From: Michael Eastham <Michael.Eastham@arun.gov.uk>
Sent: 27 October 2020 12:15
To: Planning.Responses <Planning.Responses@arun.gov.uk>
Subject: FW: BN/84/20/PL - Angels Nursery, Yapton Road, Barnham

Please upload onto Ocella the email below which is a further consultation response from the **Local Highway Authority** raising no objection to Section 73 application **BN/84/20/PL** relating to Angels Nursery, Yapton Road, Barnham.

Please find attached the [second consultation response](#) from the **Local Highway Authority** regarding planning application **BN/84/20/PL** relating to Angels Nursery, Yapton Road, Barnham.

Original Drawing Size :		A3
Scale :	NTS	Dimensions : mm
Drawing No. S278/38/16		Rev D

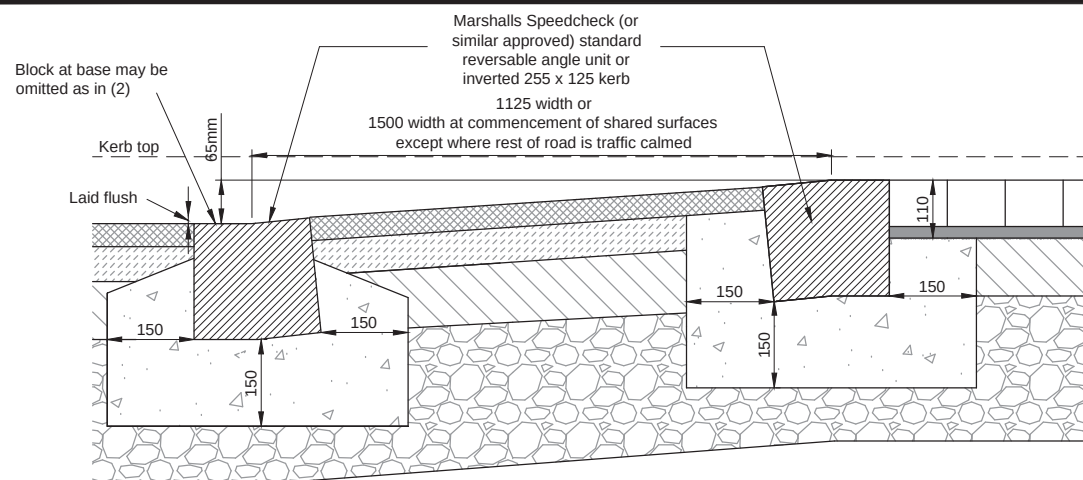
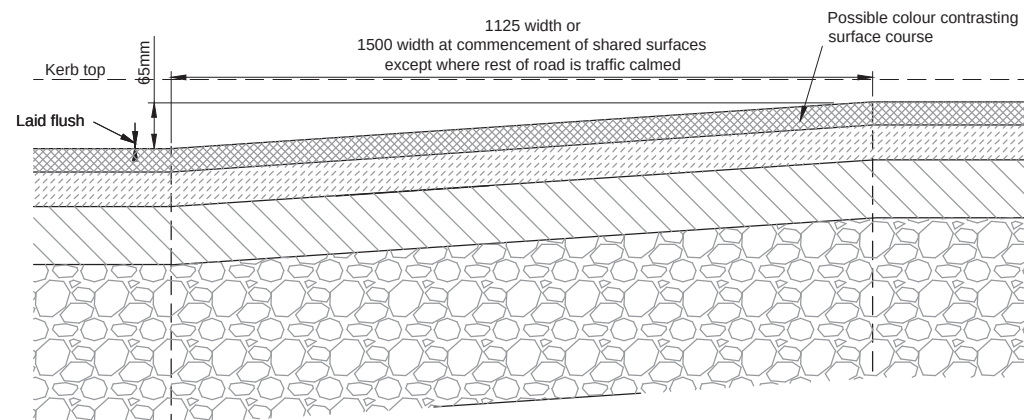
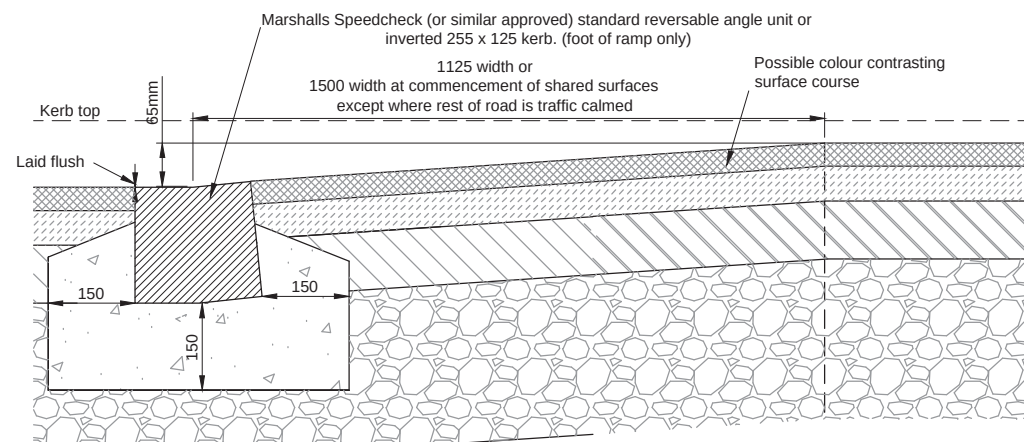
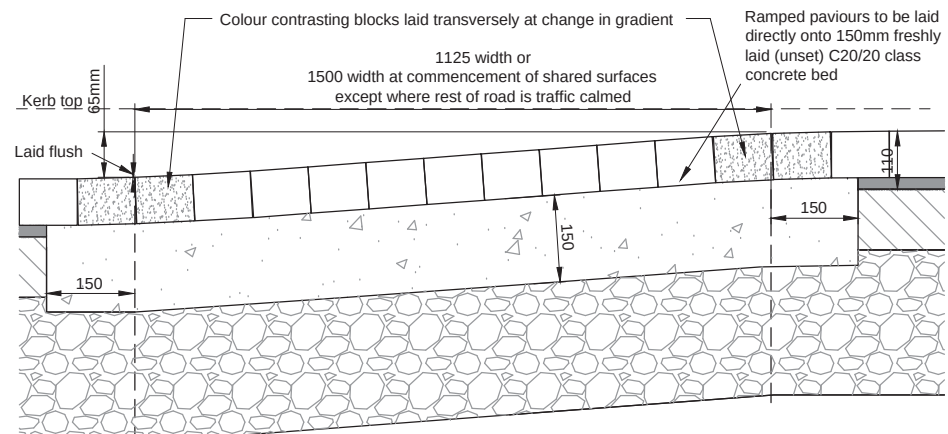
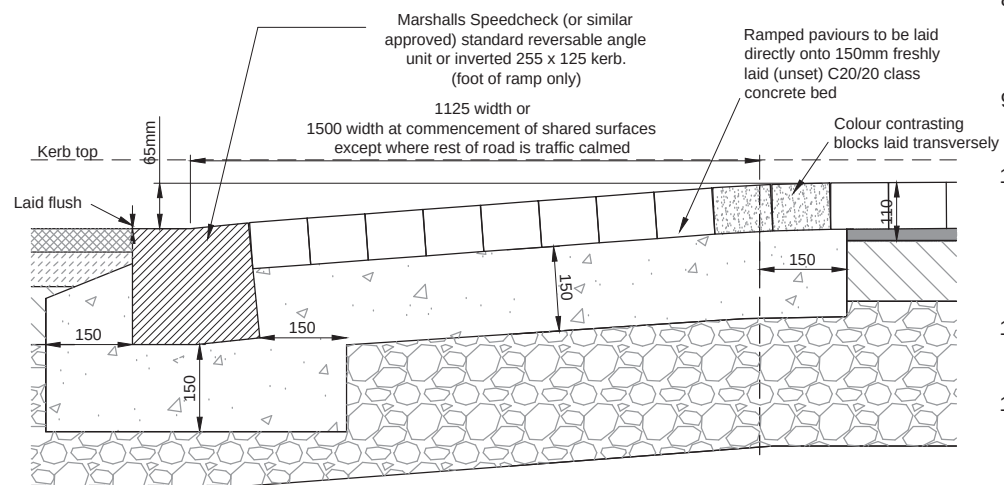
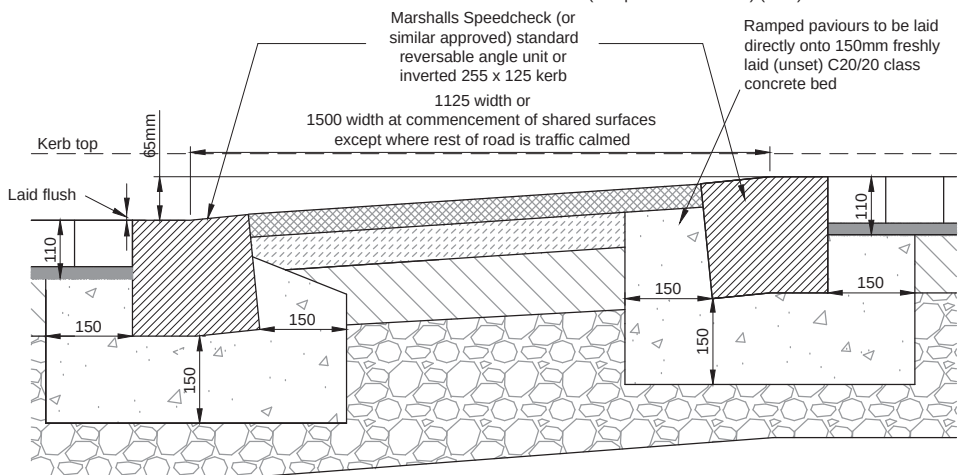
1. Tie-in points where the internal main spine road becomes 'block paved streets'. The key locations are those adjacent to plots 13 and 56. The transition from tarmac roads to block paved streets on the spine road is shown with a ramp as per WSCC standard detail.
